Request for Comments – Stadium Australia Redevelopment (SSD 10342)

I refer to your request to comment on the Response to Submissions package for SSD 10342 for the redevelopment of Stadium Australia in Sydney Olympic Park. SOPA has the following comments:

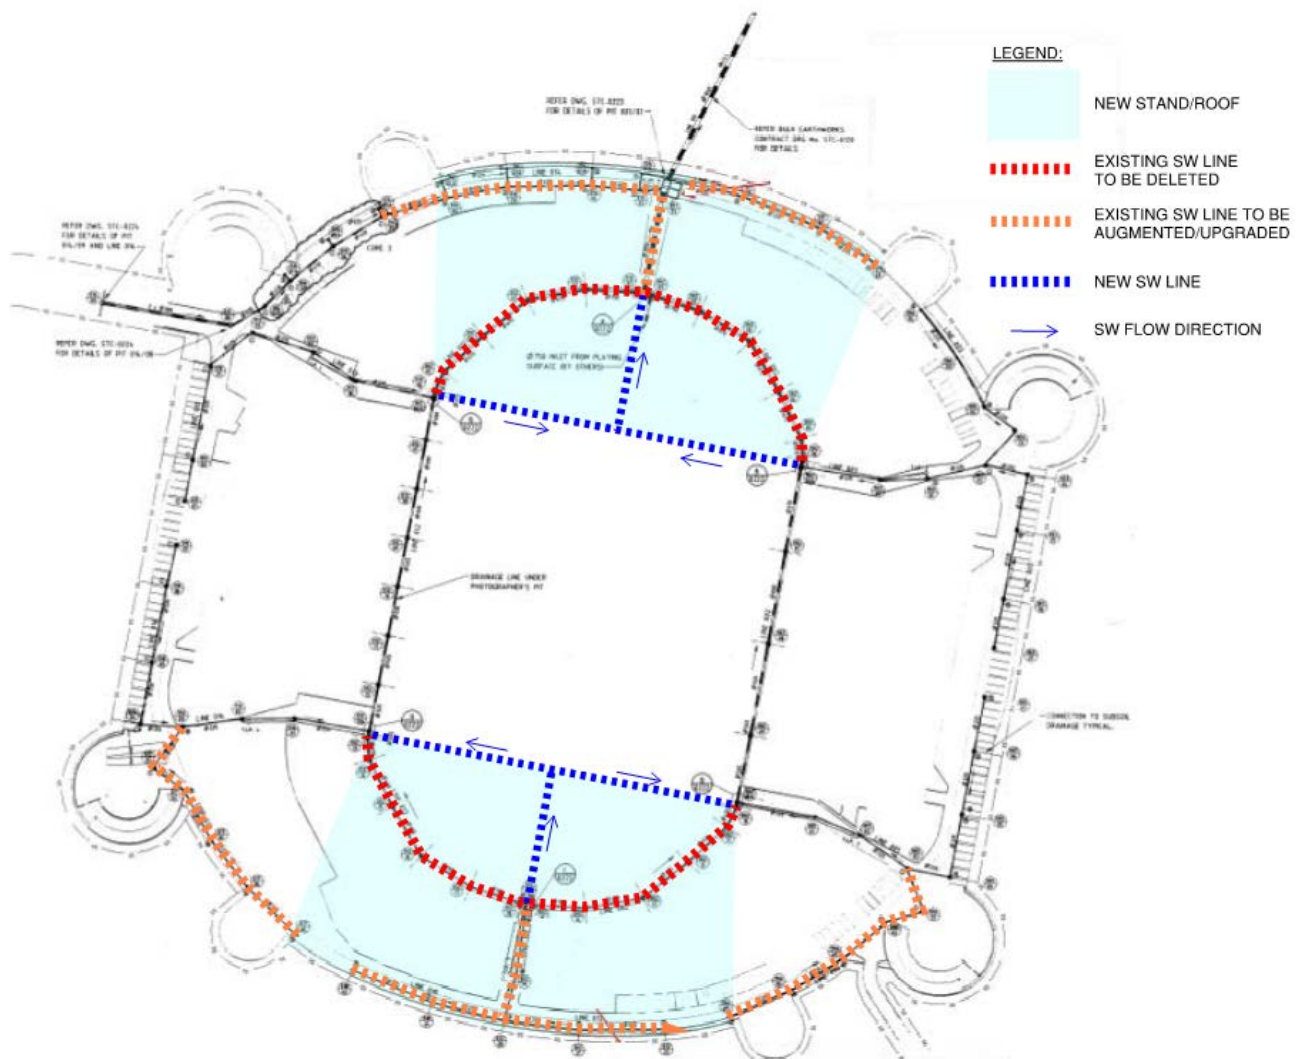
The proposed development will increase the roof area of the Stadium, which, according to the Stormwater Management Plan prepared by Aurecon, necessitates an upgrade of the existing roof drainage system.

The Stormwater Management Plan also proposes that OSD would no longer be provided below the stands to accommodate major storm events, with temporary overflows discharging to the field before draining out to the Northern Water Feature.

This increases the likelihood of chemicals and fertilisers used to treat the playing surface entering the waterway. Given that the development will rely on stormwater treatment in the Northern Water Feature to meet the stormwater quality objectives of SOPA's Stormwater Management and Water Sensitive Urban Design Policy, any additional chemicals or pollutant loads need to be carefully monitored and managed.

Prior to the issue of a Construction Certificate, a Stormwater Management Plan (SMP) must be approved by SOPA's Director – Environment and Planning and submitted to the Certifying Authority. The SMP must be in accordance with SOPA's Water Sensitive Urban Design (WSUD) Policy and must include the following information:

On this basis, SOPA considers the requirement for the applicant to obtain SOPA's approval for the final Stormwater Management Plan prior to the issue of a Construction Certificate to be reasonable and relevant to the proposed development. Accordingly, SOPA requests that the above condition form part of any consent.
